15 November 2010

Our Ref: P3A-2010/2
Contact: Marta Sadek - 9562 1743

Re: MP09_0169 MOD 1 - Stage 1 - 78-98 Arncliffe Street & 31-47 Princes Highway, Wolli Creek

**SIGN SP1 - SIGNAGE PYLON TYPE ( 3 SIDED SIGN)**

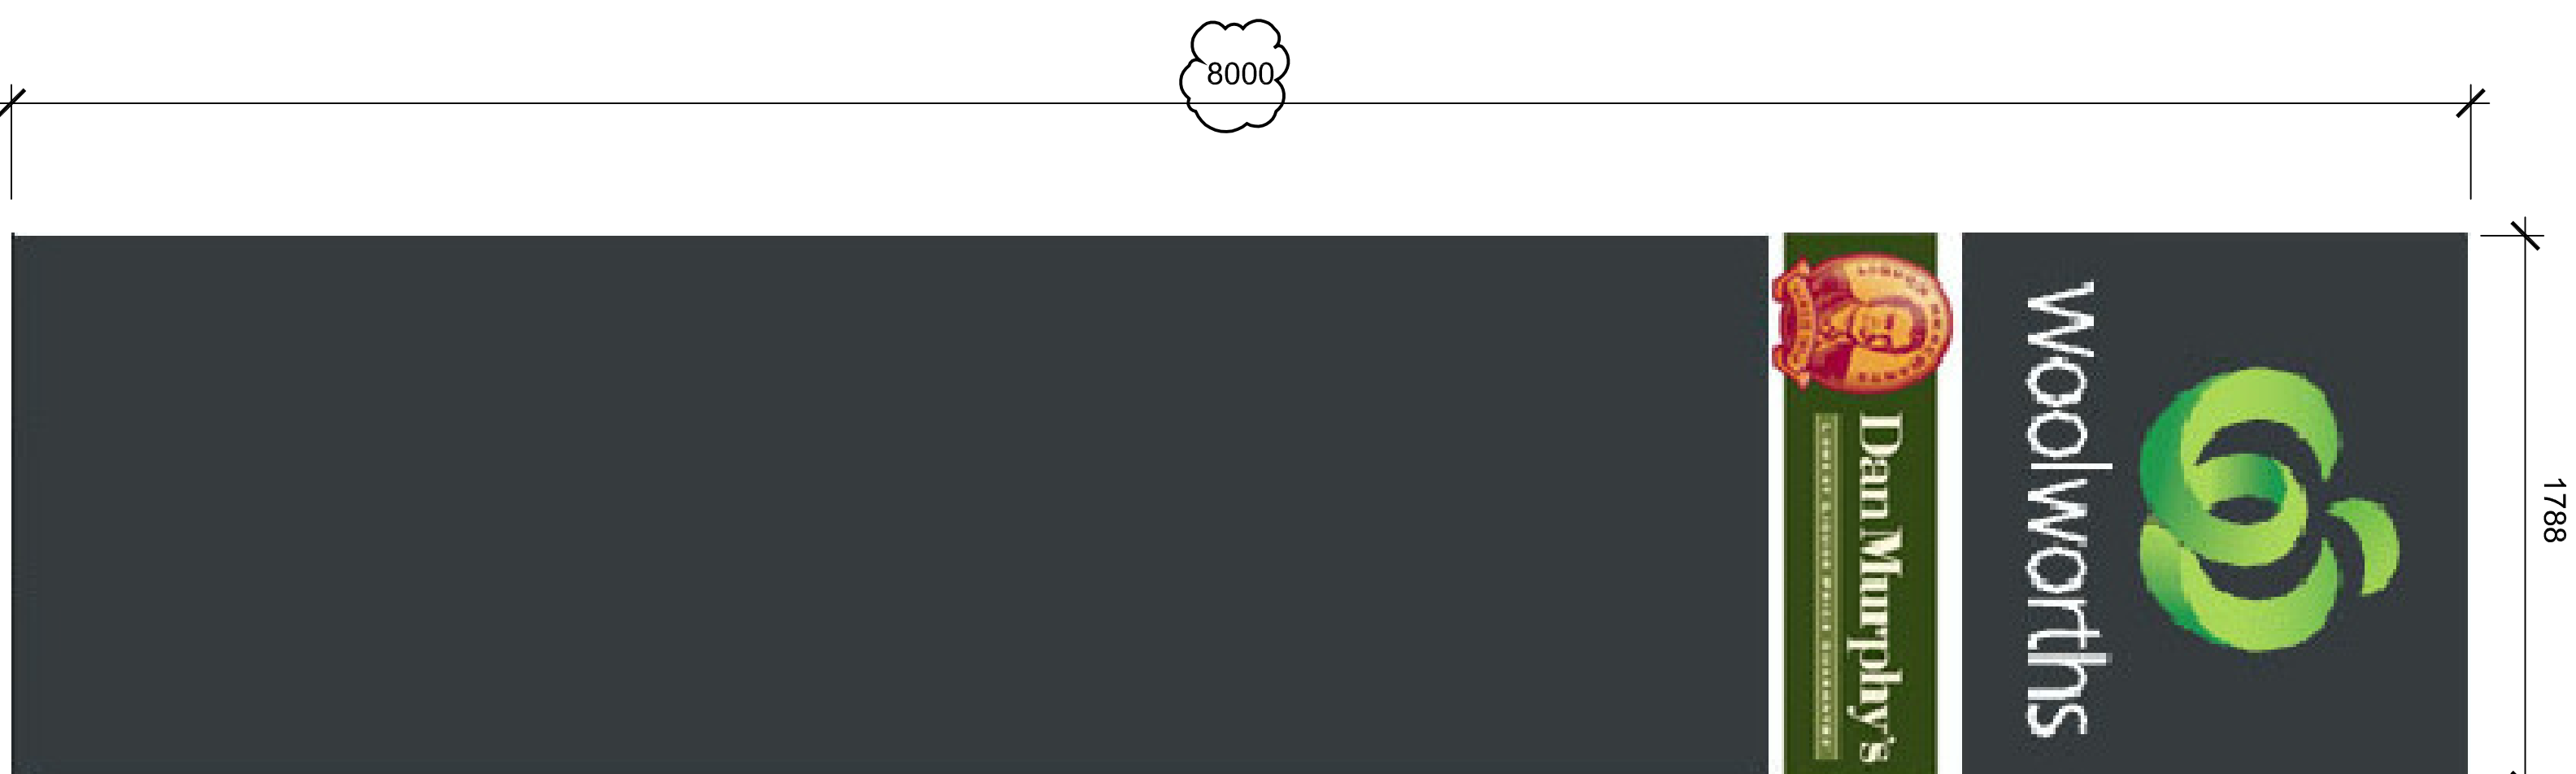
Whilst the applicant has submitted more detailed plans and statements to support the proposed signage strategy, there are concerns regarding the cumulative impacts of signage in the locality. Details such as the degree of illumination has not been provided, nor a photomontage to demonstrate that the signage (particularly the pylon sign) meets the Assessment Criteria under Schedule 1 of SEPP 64 in regards to illumination, streetscape, setting and character of the area. It is noted that the height of the pylon sign is not supported by Council's DCP 29 – Outdoor Advertising and draft Rockdale DCP 2011. A maximum height of 6m is required for a pylon sign under DCP 29.

NORTH EASTERN ELEVATION SCALE 1:100

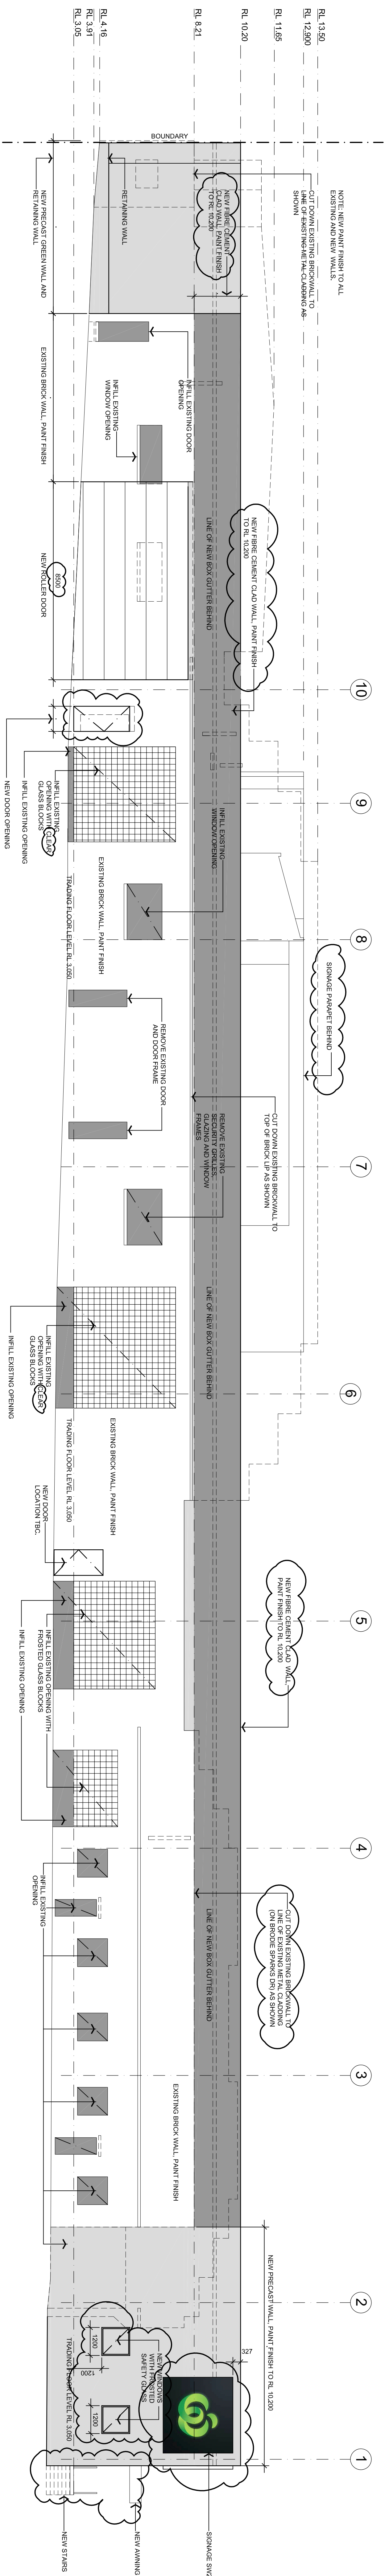
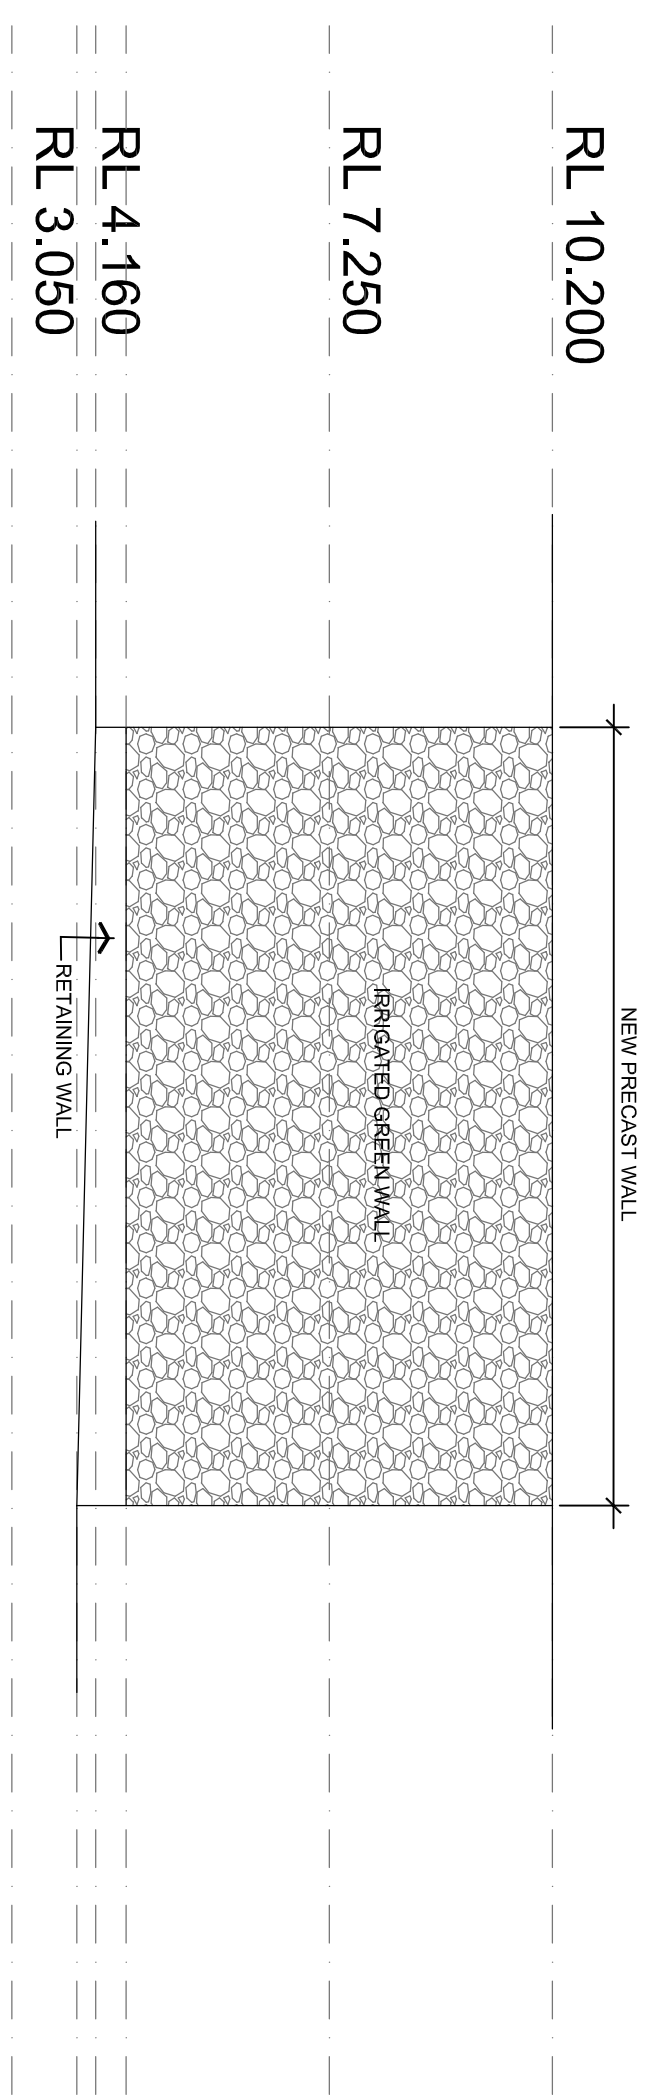
The modification plans include numerous changes to the façade of the building from the approved plans which have not been annotated as changes. For example, the rendered spandrel on the Arncliffe Street elevation that is shown on the approved plans is not included on the modification plans and the top of glass brick openings are shown as consistently finishing at RL 10.200, whereas the modifications plans show them at different heights. Such changes are not supported.

Annotated changes on the modification plans are also not supported, such as the substitution of the flat sheet metal sheeting with fibre cement wall cladding, paint finish.

The proposed elevational treatment in the modification plans will result in a significantly inferior design outcome that is not commensurate with the development's important location. It is recommended that the drawings be revised so that they accord with the materials selection and design detailing in the approved plans.
